Dear Sirs, Re. BR/48/18/PL under BR/71/12
 1 Brodrick, Castle Close, Sylvan Way -

I wish to object to the above planning application to insert seven windows into the roof of the above property and also a double sliding sash window into the front gable of the house to facilitate the use of the attic.

Title
PROPOSED ELEVATIONS

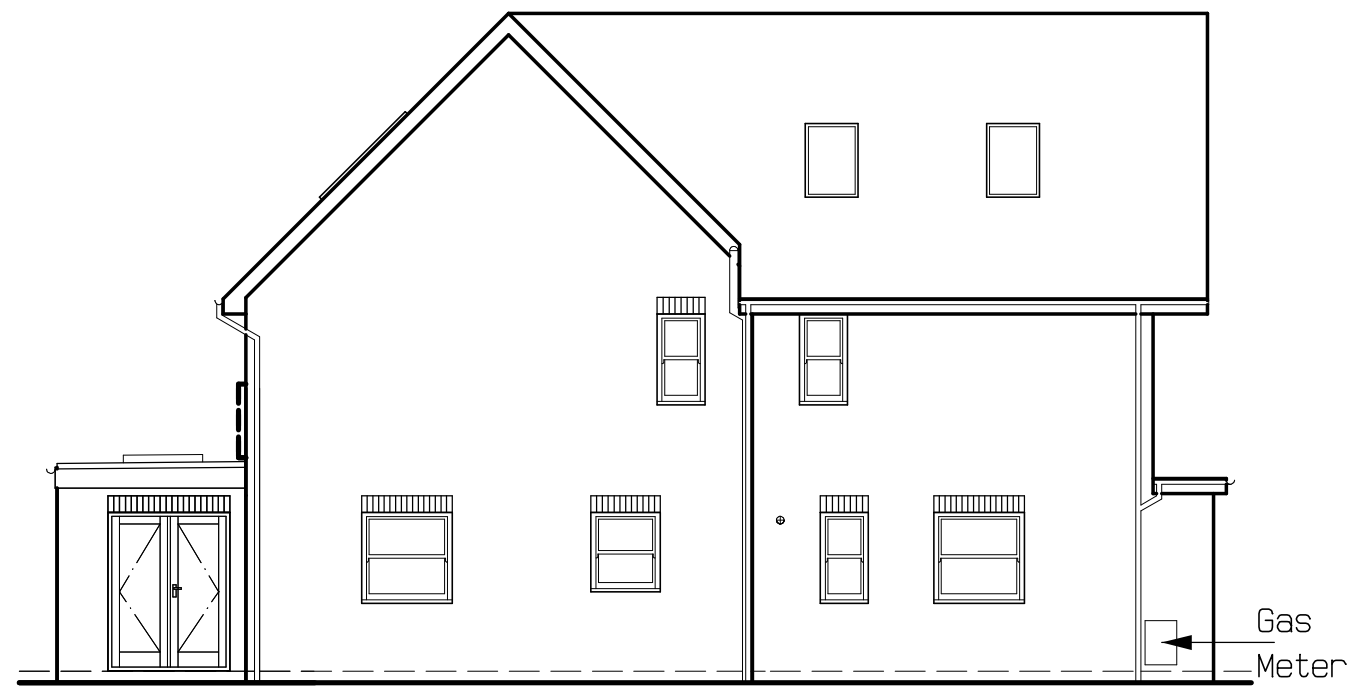
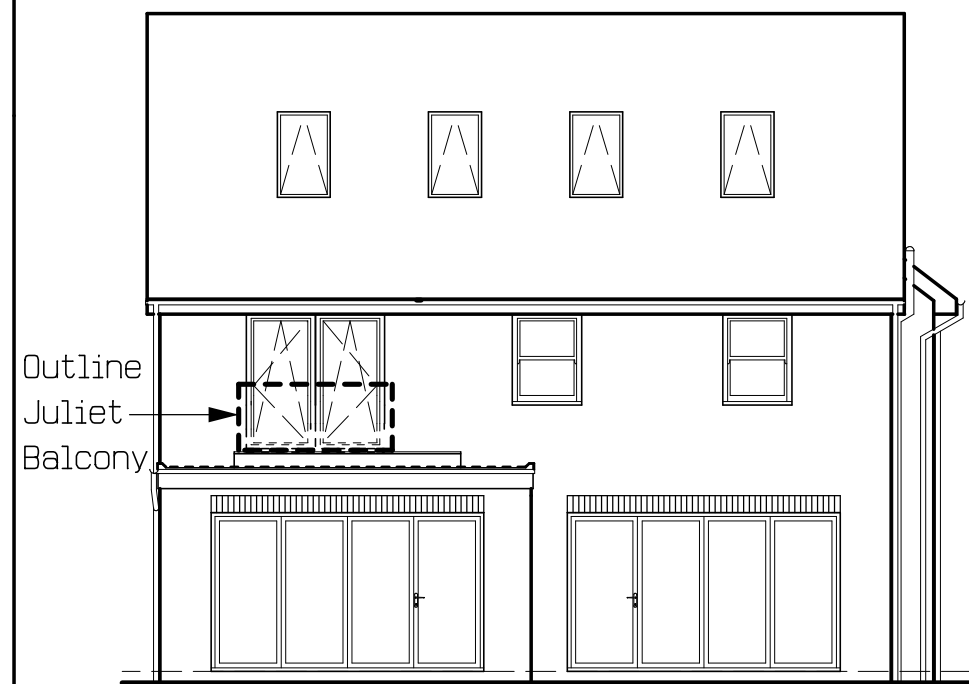
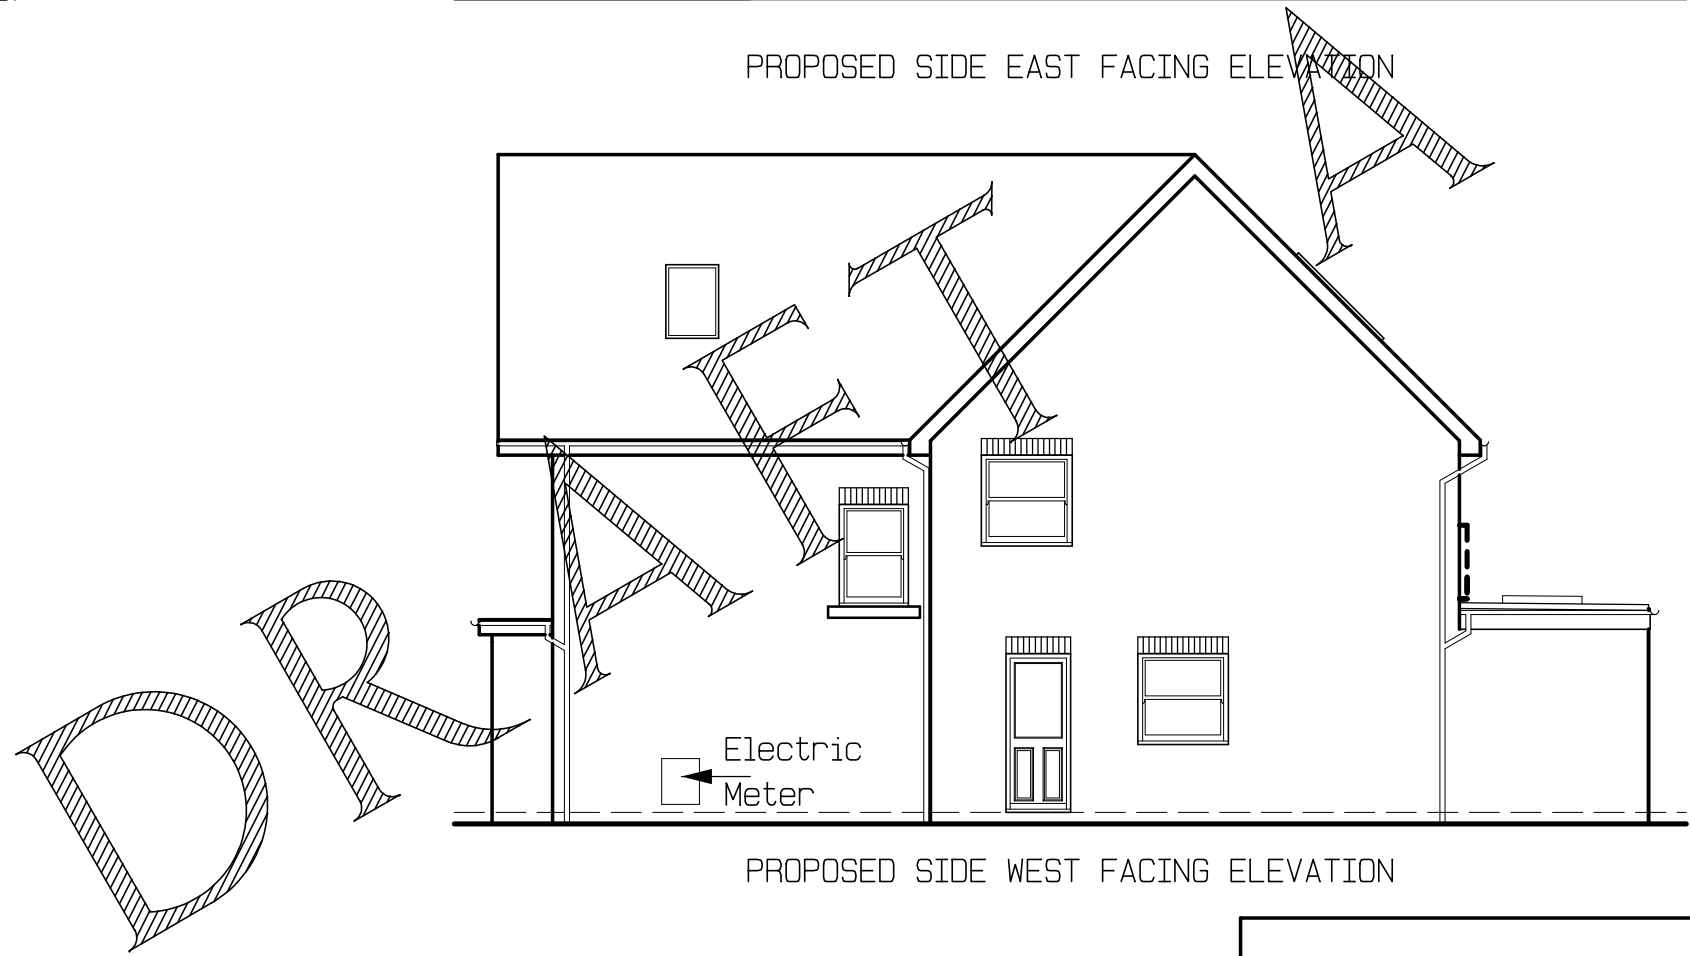
The reason for my objection is the gradual increased development of this large property. The insertion of many windows into the roof and the upper part of the front gable to increase living space will increase overlooking of the existing properties in Sylvan Way and Victoria Drive which have previously never been overlooked.
